**Planning Applications, Ribble Valley District
3/12/0692 Henthorn Road, Clitheroe**

I am recommending that the discharge of Condition 27 does not proceed at this time as it does not provide a satisfactory means of access from the proposed site to the public highway at Edisford Road, Clitheroe.

Project  
HENTHORN ROAD  
CLITHEROE  
TAYLOR WIMPER  
Title  
CYCLEWAY AND PATH LINK

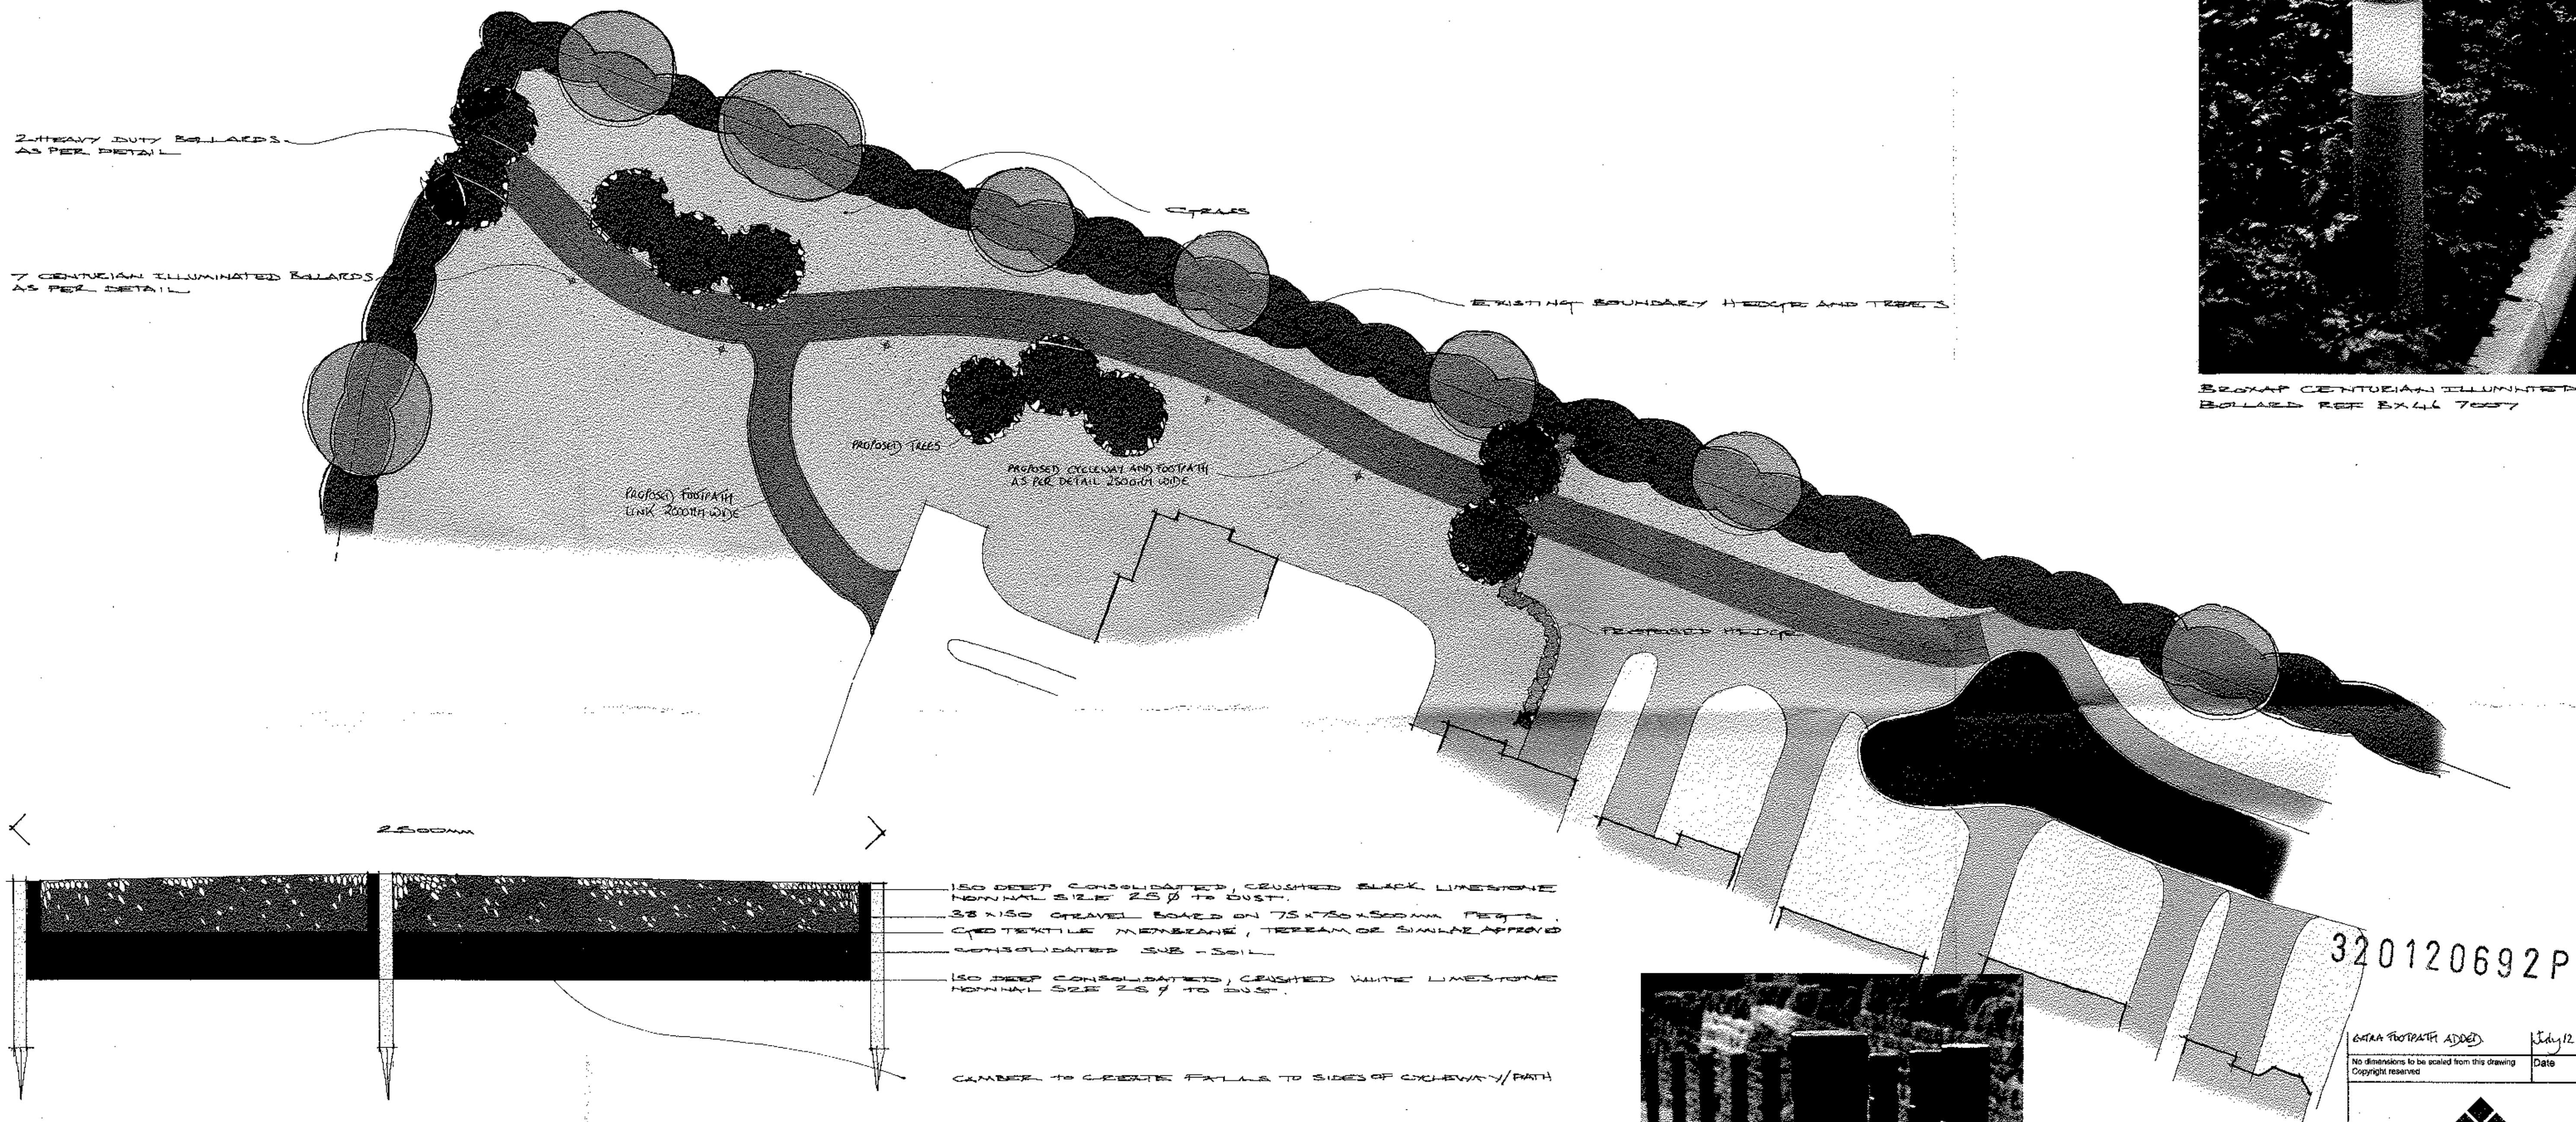
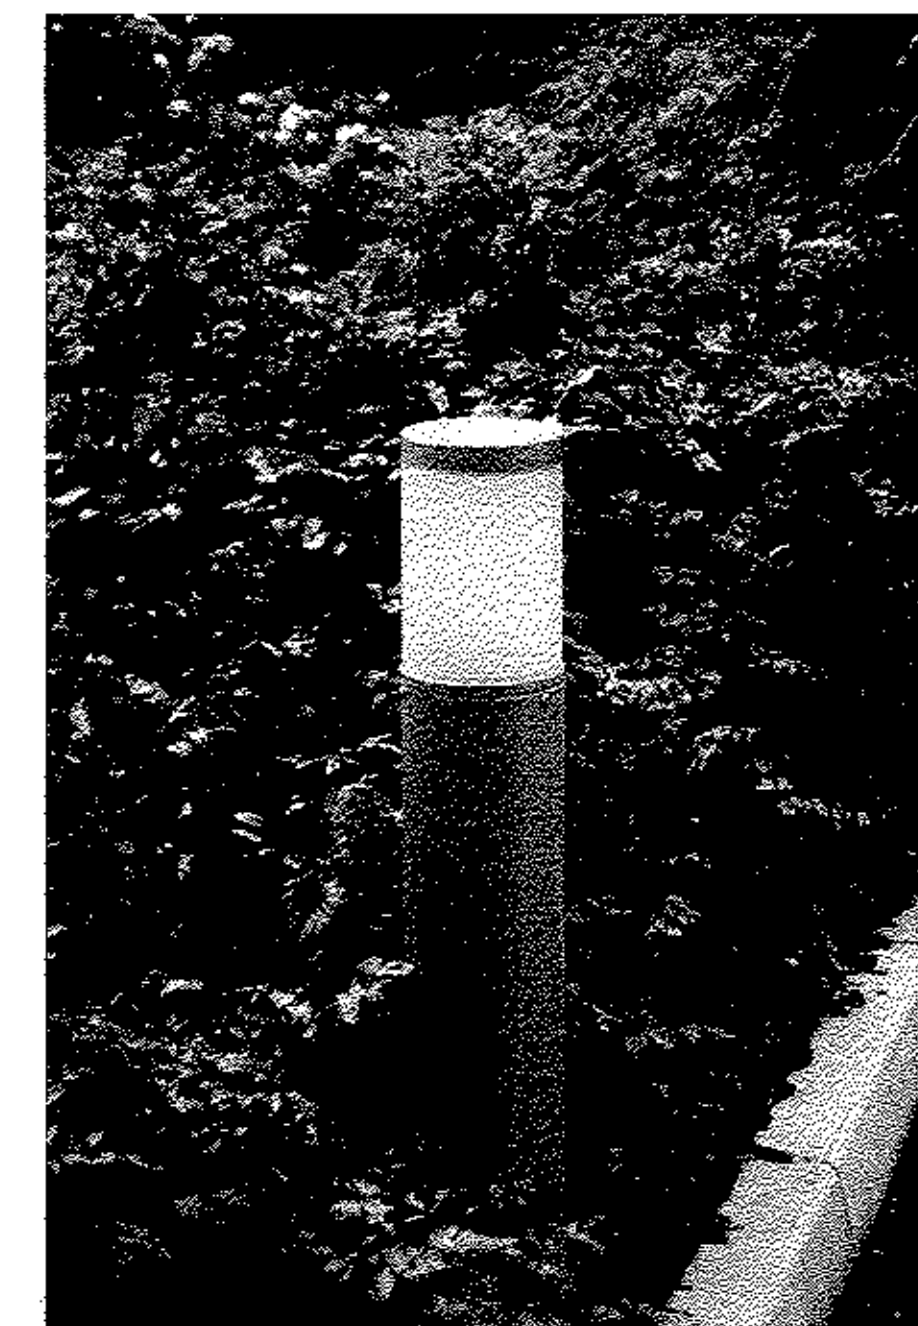
The proposed design of the pedestrian/cycle link to the access road to Edisford Caravan Park is consistent, in part, with that envisaged in relation to the previous application, 3/2010/0719. The link from the site to the caravan service road is acceptable and could be implemented as per the relevant drawing (4271.01 Rev A, received by Ribble Valley Borough Council on 1 August 2012), when included in a more extensive scheme linking the development site to the public highway.

However, the proposed layout provides only a partial resolution of the sustainability issues raised in relation to a secondary access to the site and stops short of linking the development to Edisford Road, from where local services and facilities can be accessed via the local highway infrastructure.

In order to provide a satisfactory solution to this matter and to allow Condition 27 to be successfully discharged, the proposed pedestrian/cycle link from the site must secure a direct means of access to Edisford Road.
